**WEST SUSSEX COUNTY COUNCIL
INFRASTRUCTURE CONSULTATION**

DATE: 10/08/2009

SUBJECT: LU/190/09 - Porposal to convert a redundasnt coastguard tower to a residential property to include a COU

Littlehampton Coastguard Tower, The Promenade, Arun Parade, Littlehampton, West Sussex, BN17 5LL

SITE PLAN - SCALE 1:200

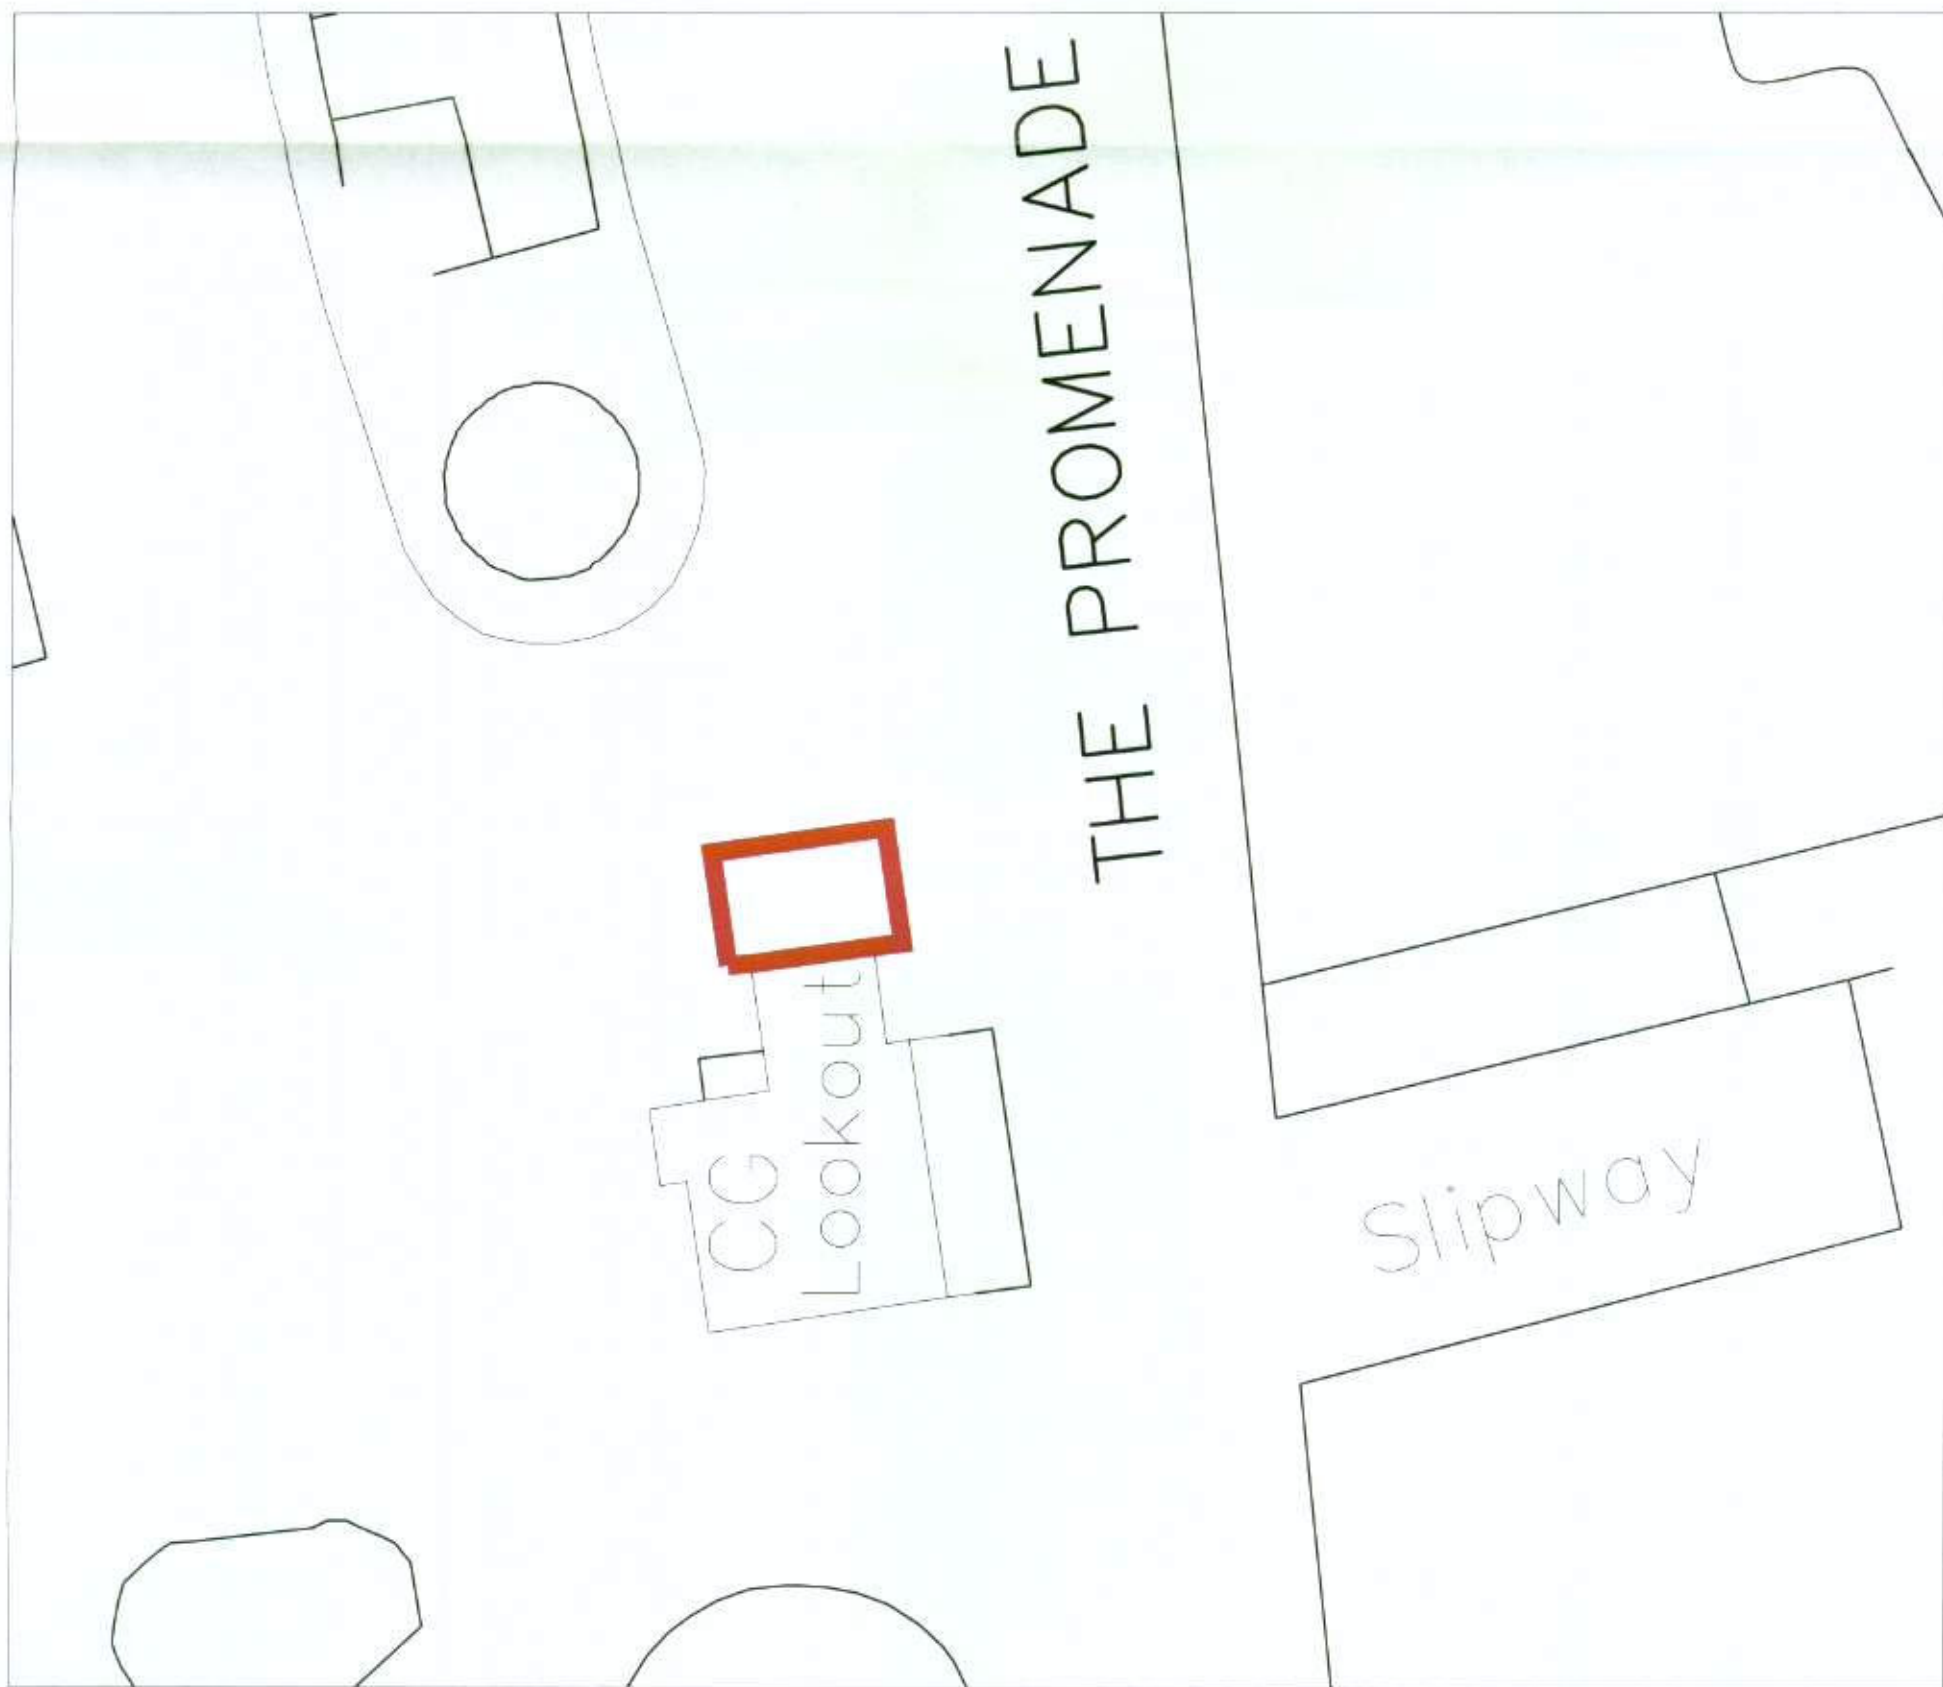
Cycle parking should be included however; this must be secure, covered and be capable of storing at least one cycle per bedroom of the proposed dwelling. The actual details of the cycle parking facilities should be submitted to and approved by the Local Planning Authority (LPA). To accommodate cycle parking any cycle store should have minimum dimensions of 6m x 3m.

For the purposes of this application, the residential use is assumed to have a nil car parking provision. A nil car parking provision does accord with the WSCC maximum parking standards and no highway safety concerns would be raised to a nil car parking provision in this location. In terms of transport, the property is situated in a sustainable location. The property is within walking distance of a range of services and public transport; hence there should no reliance as such on the use of the private car. This application therefore is in compliance with PPG13 in encouraging the use of sustainable transport.

If the LPA are minded to approve this application, a condition securing cycle parking prior to occupation of the building, should be included.
